# ENG-SF22025-R1-CDs.pdf Markup Summary

PCD File # 22-025

EAGLE WING DRIVE (PUBLIC) & EAGLE WING VIEW (PRIVATE)
 STA 1+54.66 TO 3+35.96 & STA 3+35.96 TO 11+92.62

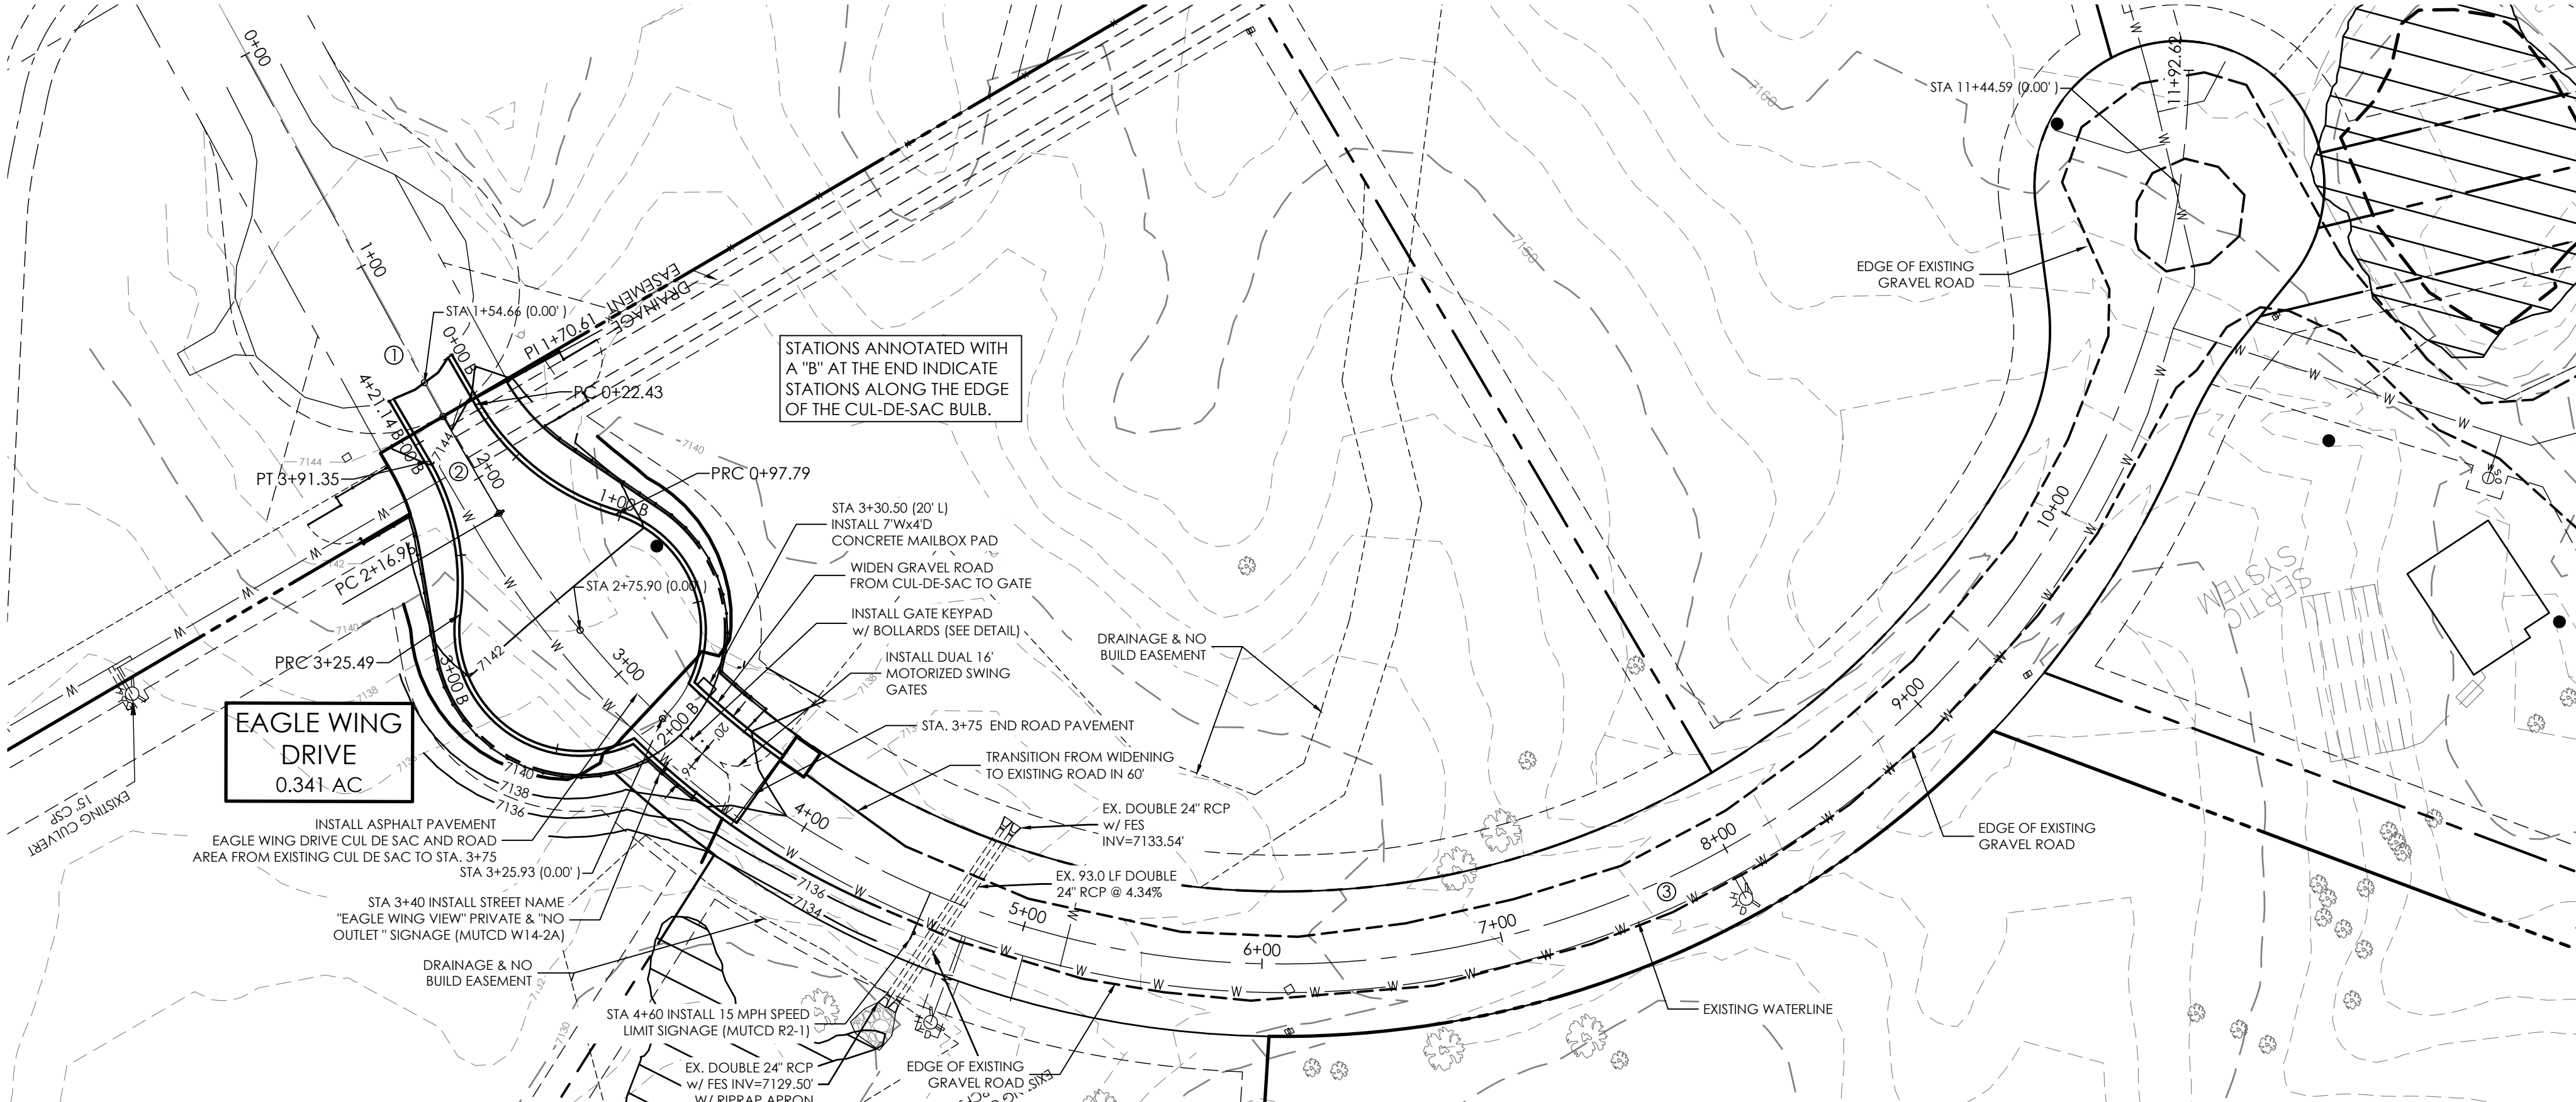
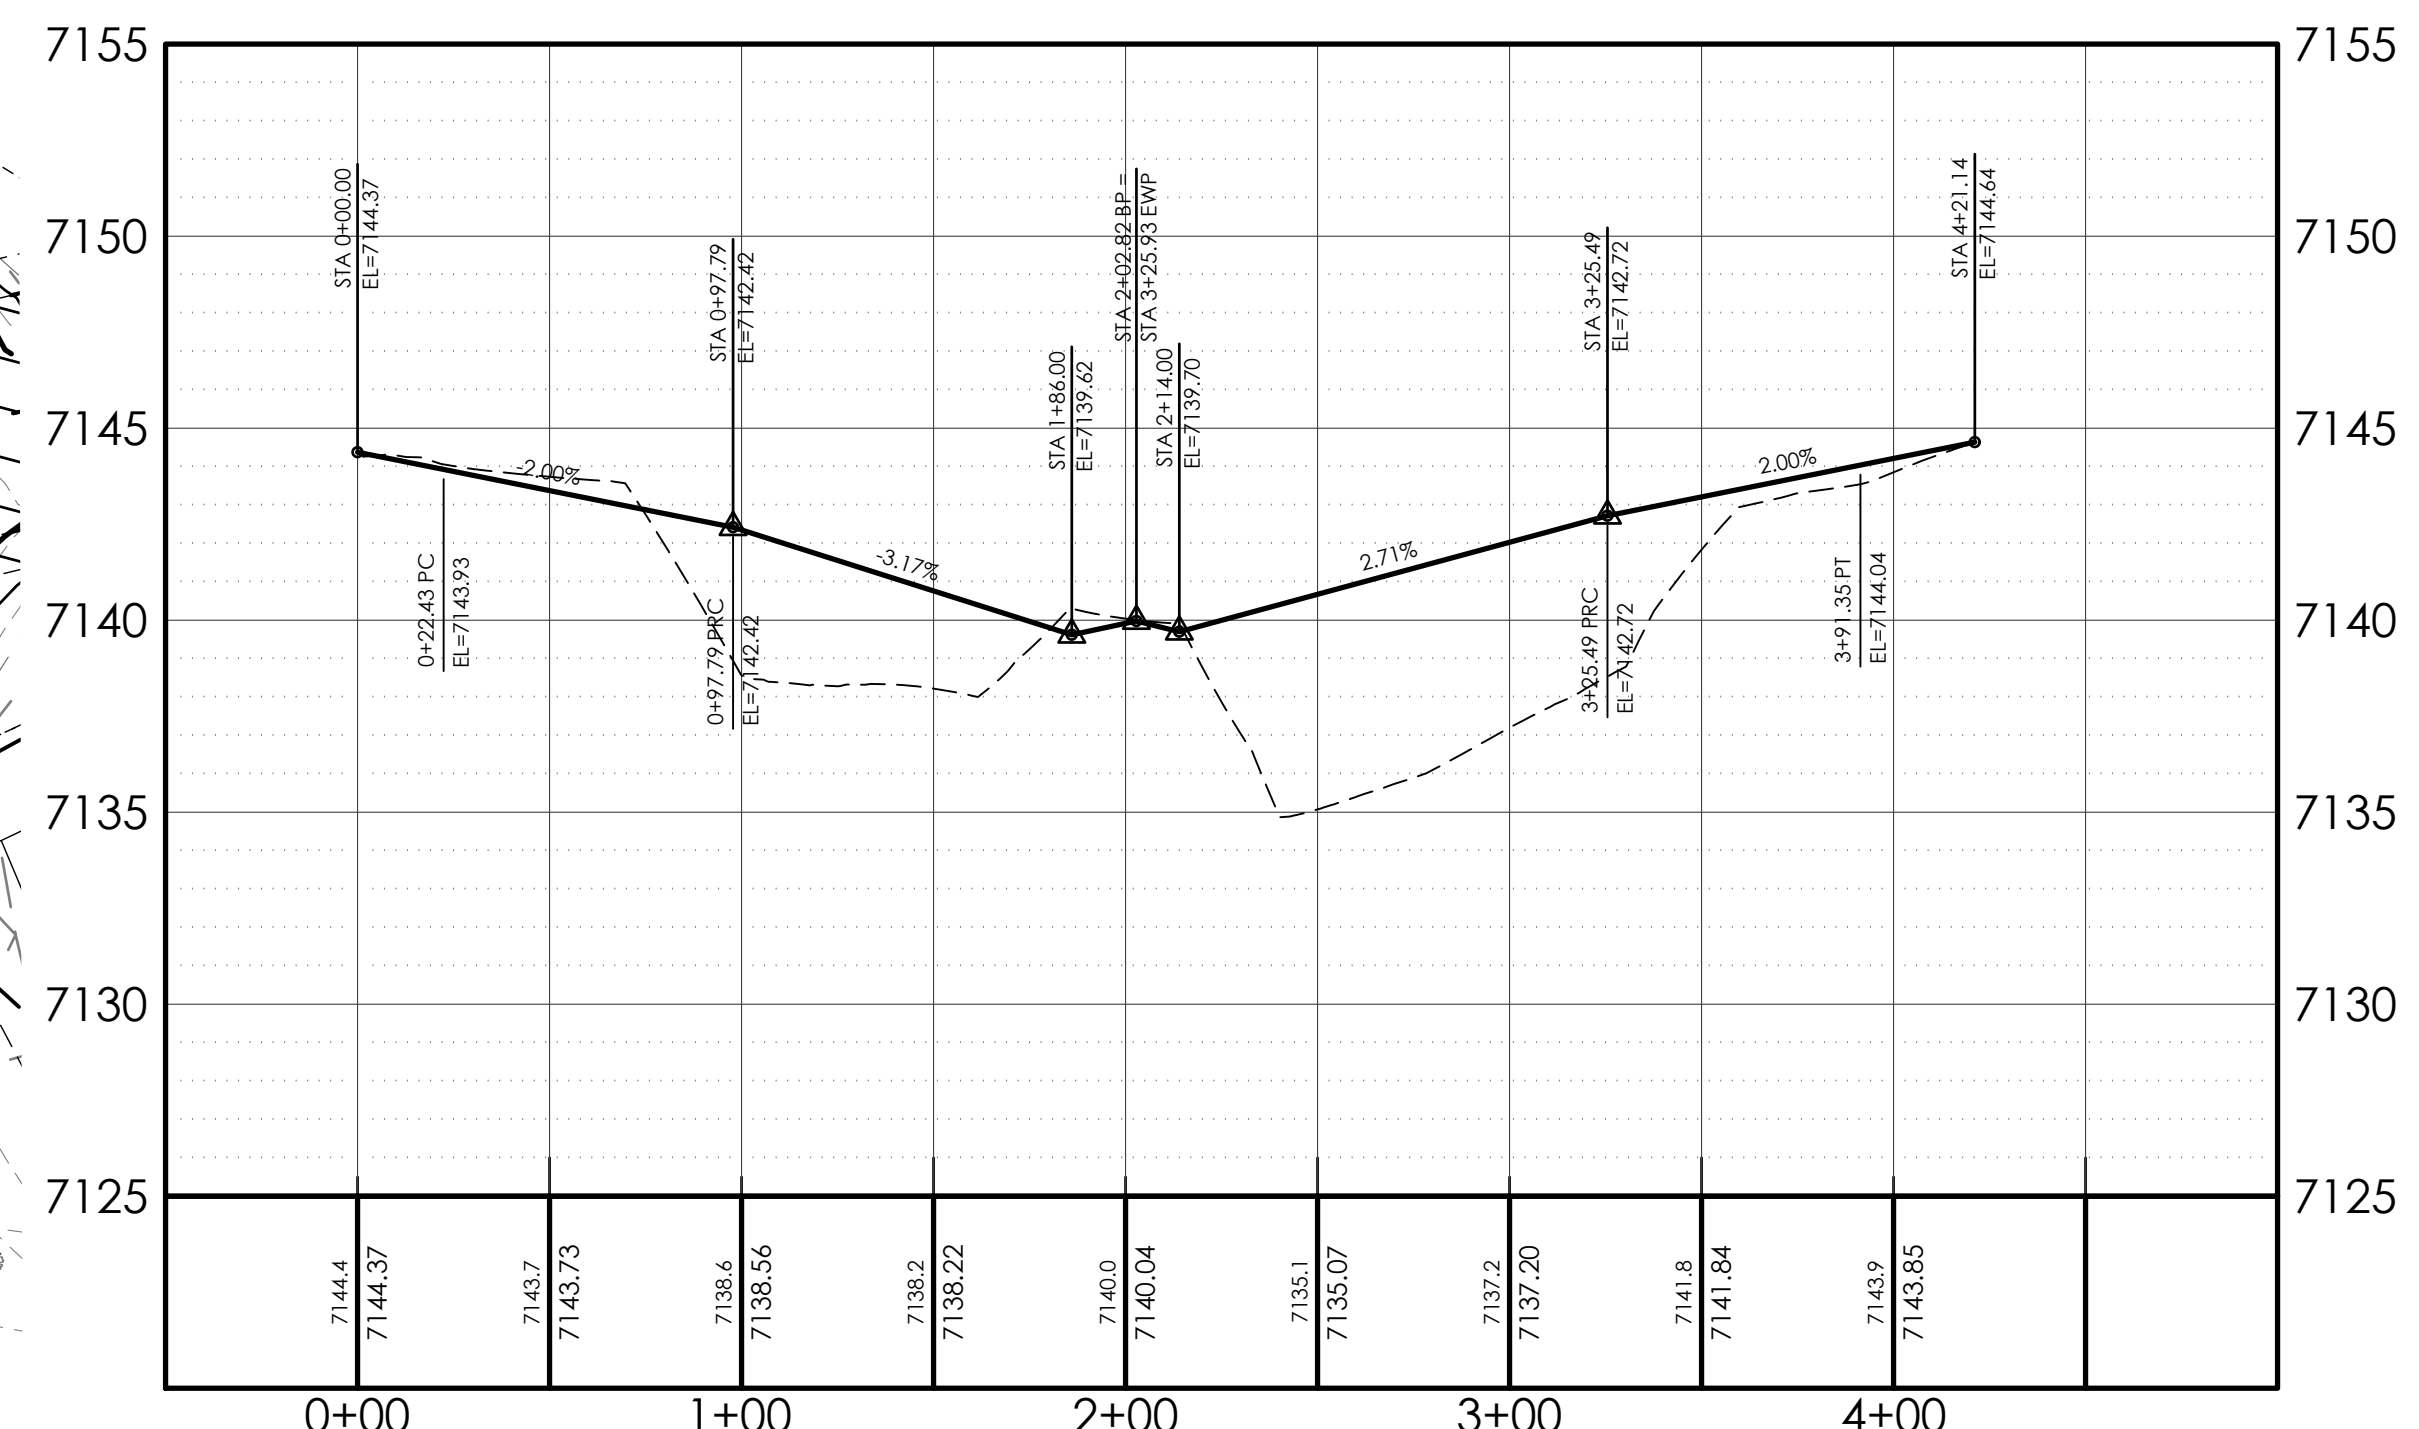
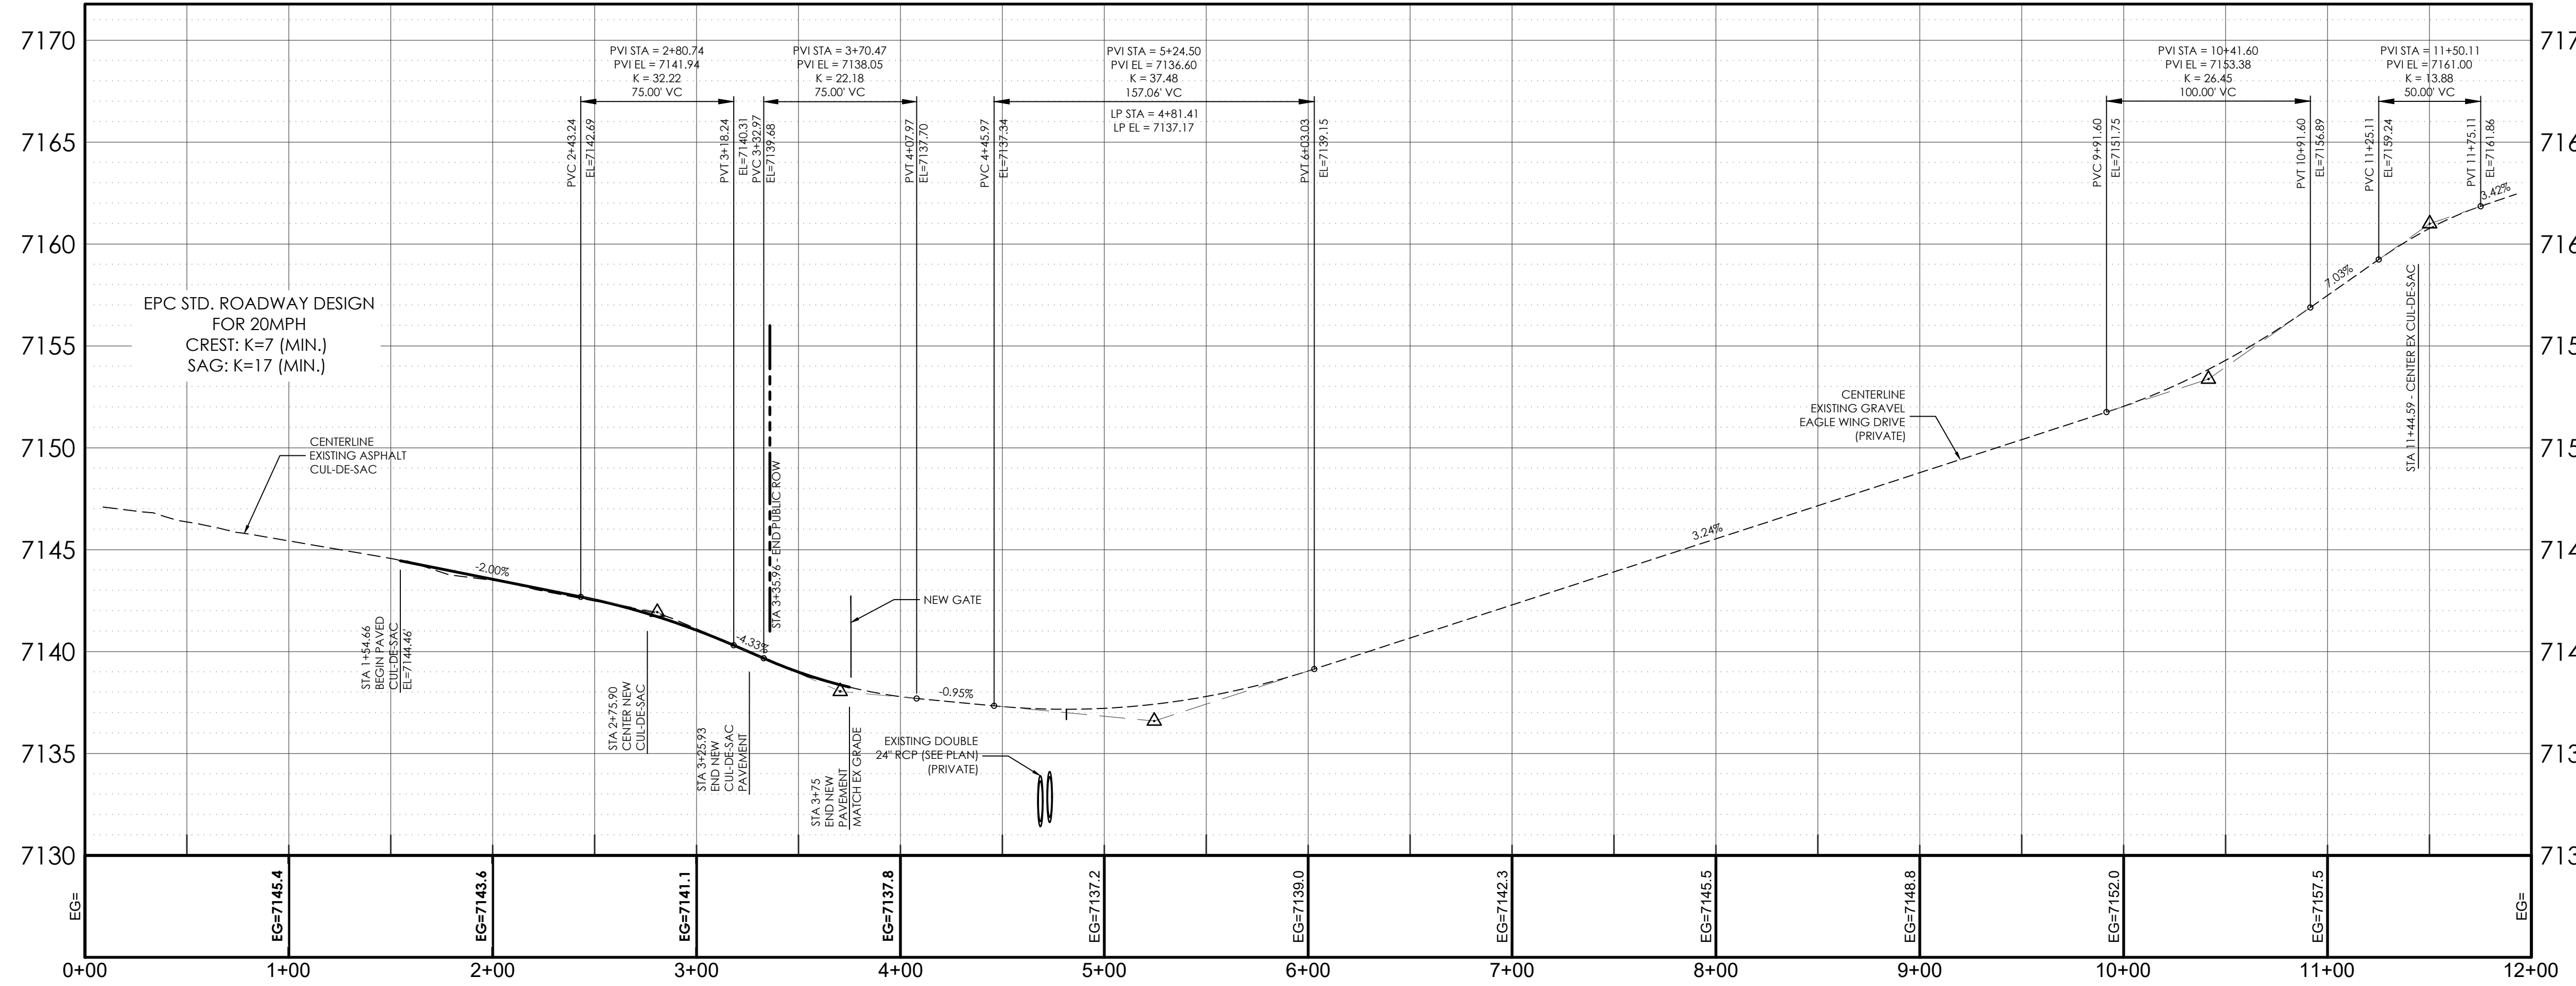
Adjust to meet K value of 37

Add posted speed 25mph

Adjust cul-de-sac grade to meet criteria

Label existing road grade. Why are there 2 lines?
